Our ref: DOC22/174209

Your ref: SSD-10472-MOD 2

15 March 2022

Subject: EES comments on the Modification of the Museum Discovery Centre – SSD-10472 MOD 2 – 172 Showground Road, Castle Hill - Change to Tree Replacement Implementation Plan and conditions

3.4 Arnold Avenue Sports Complex Reserve, Kellyville

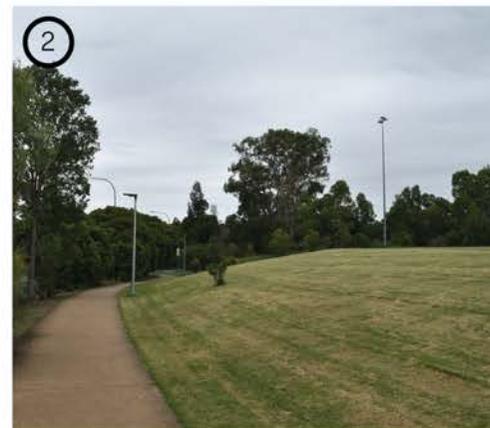
The TRIP indicates Council's preference is that all 74 of the replacement trees are planted at Arnold Avenue Reserve at Kellyville (Section 3 of TRP). This reserve does not appear to be adjacent to existing remnant of Cumberland Plain Woodland or other TEC as proposed by the TRS. Nor does the Centenary of ANZAC Reserve which has also now been nominated by Council, although there is a mapped TEC on adjacent land to the north along Smalls Creek.

EES recommends the replacement planting is undertaken in the Hills Shire LGA as originally proposed to contribute to improving biodiversity values in the LGA. Also, the site (s) selected for the off-site planting should protect the replacement tree plantings in perpetuity.
